Date 09 December 2019

RE: 6/2019/1788/COND – Former Shredded Wheat Site, Broadwater Road, Welwyn Garden City, AL8 6UN

Thank you for re-consulting us on the above application for the submission of details pursuant to condition 5 (Surface water Discharge) 6 (Drainage System) 52 (Provision of open space/play space) 35 (Delivery of accessible Housing) 13 (Highways) 37 (Vehicle access Point to Pall Mall Site) 50 (Refuse Storage Arrangements) on planning permission 6/2018/0171/MAJ, at Former Shredded Wheat Site, Broadwater Road, Welwyn Garden City, AL8 6UN.

CATCHPIT MANHOLE DETAIL (SCALE 1:20)

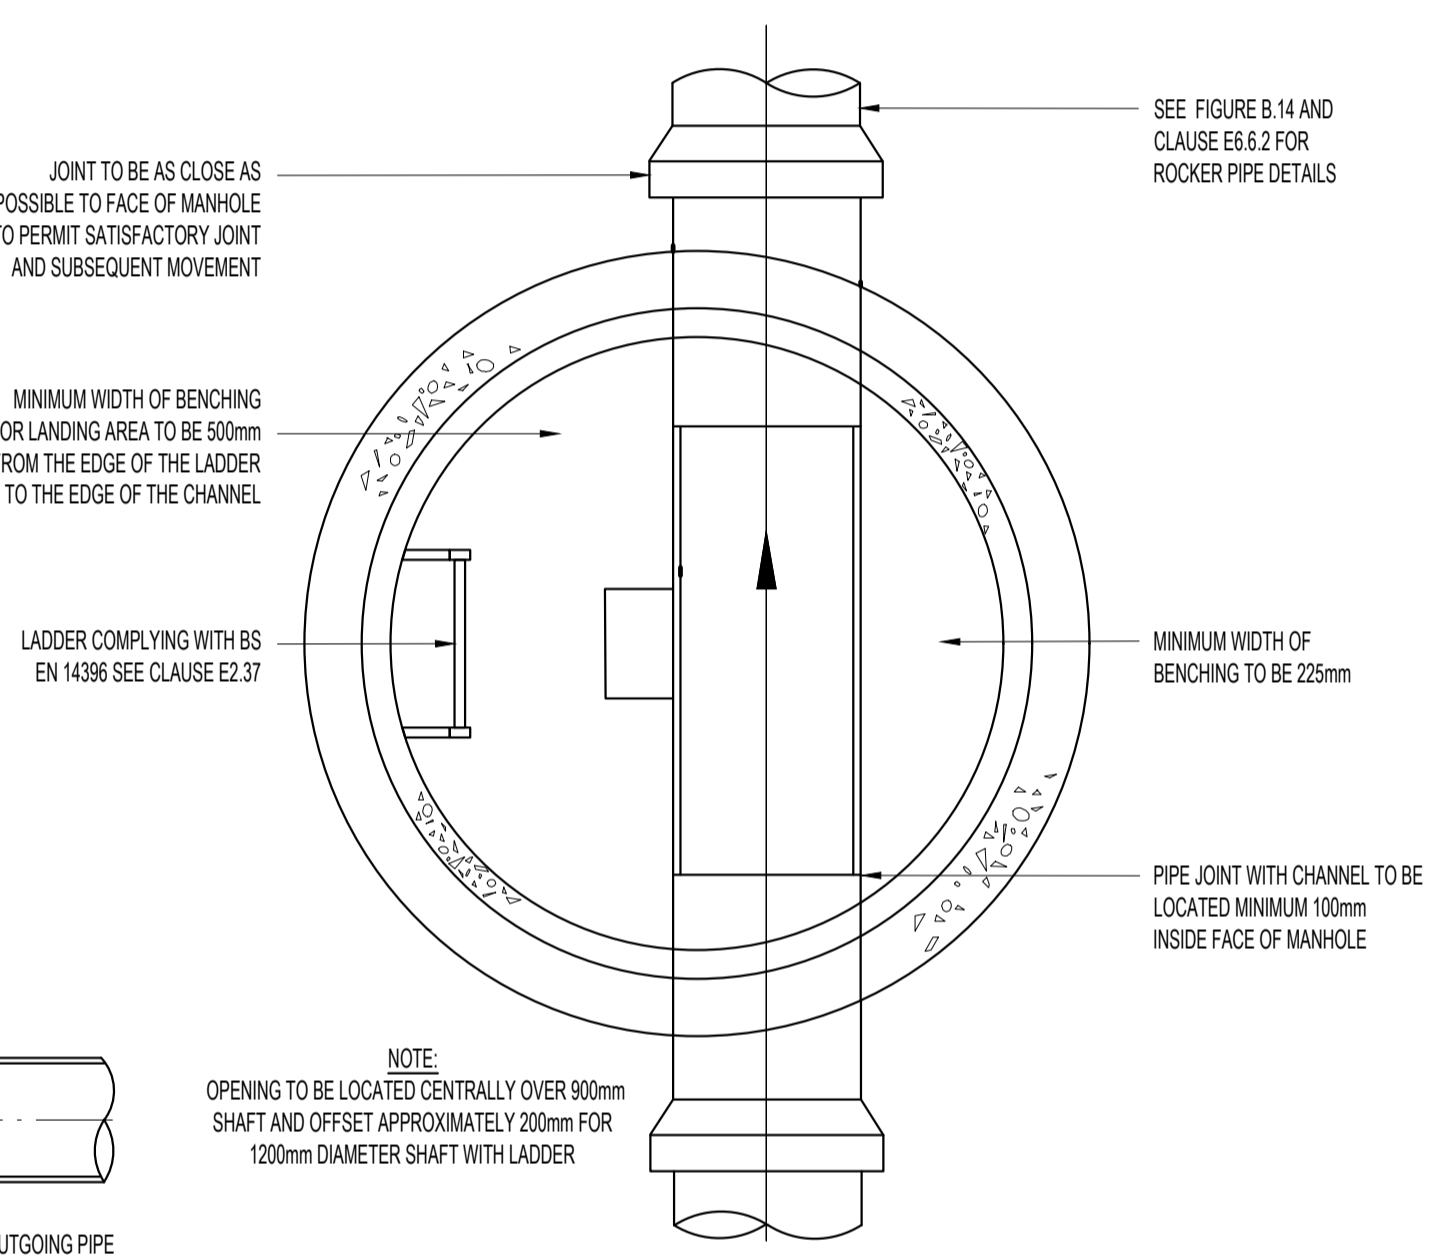
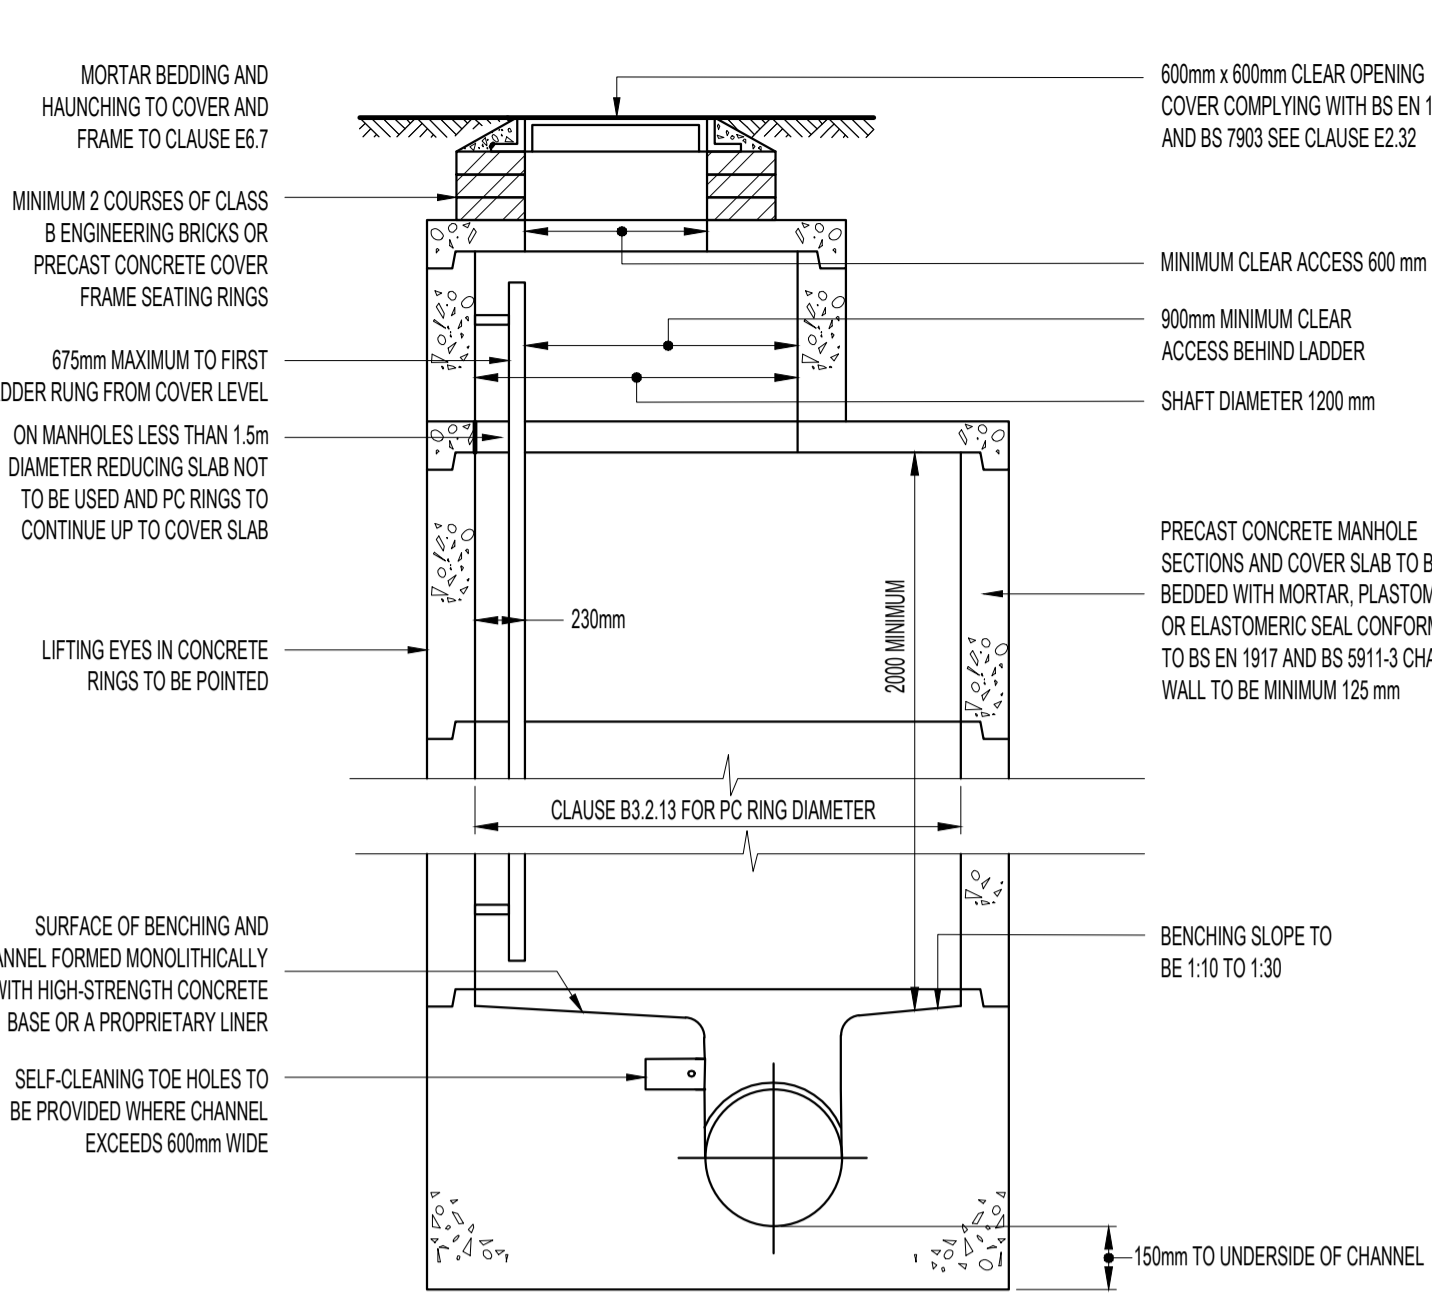
We note that 2 hydrobrakes flow controls have been identified on a drainage layout drawing. We note as well that catchpit manholes have been proposed at each attenuation tank.

PROPOSED DRAINAGE LAYOUT (PHASE 1)

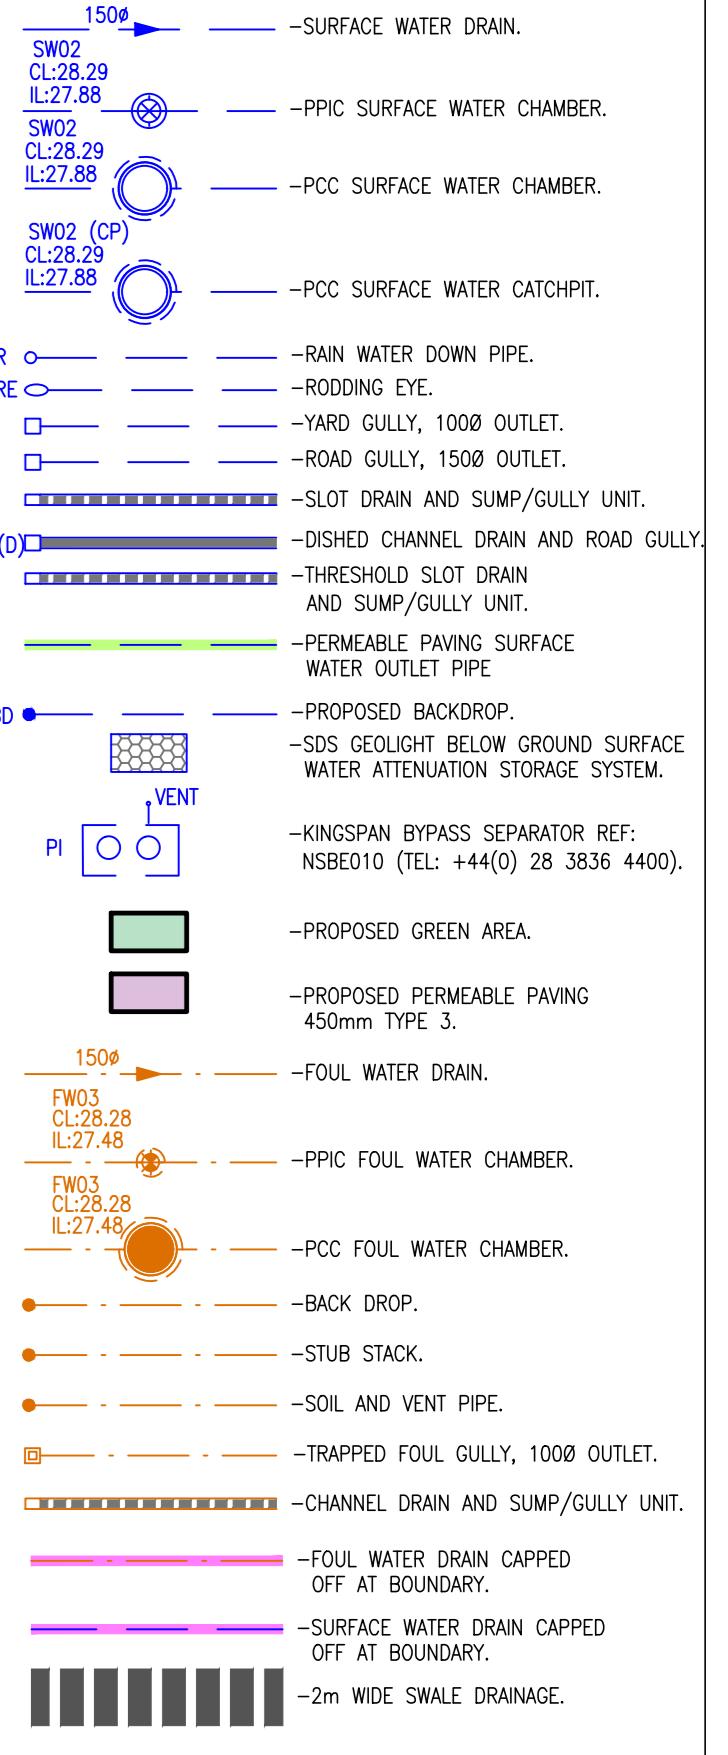
Moreover, in the same point the applicant has indicated that 3 surface water outfalls are being proposed with a total discharge rate of 12.91 l/s. However, based on the drainage drawing that the applicant referred to 066571-CUR-00-00-DR-C-90003 "PROPOSED DRAINAGE LAYOUT (PHASE 1)" we were only able to identify 2 outfalls from the site for phase 1. Therefore, this should be clarified by the applicant. In addition, based on the response to Thame Water dated 28/11/2019, the applicant has indicated that a maximum of 6.1 l/s of surface water discharge for phase 1 has been proposed. This is inconsistent with the information submitted to the LPA before and the additional information included

in the letter to the LLFA. This should be clarified. The final area and drainage sub-catchments included in phase 1 of the development have to be identified, clarified and full drainage details should be provided.
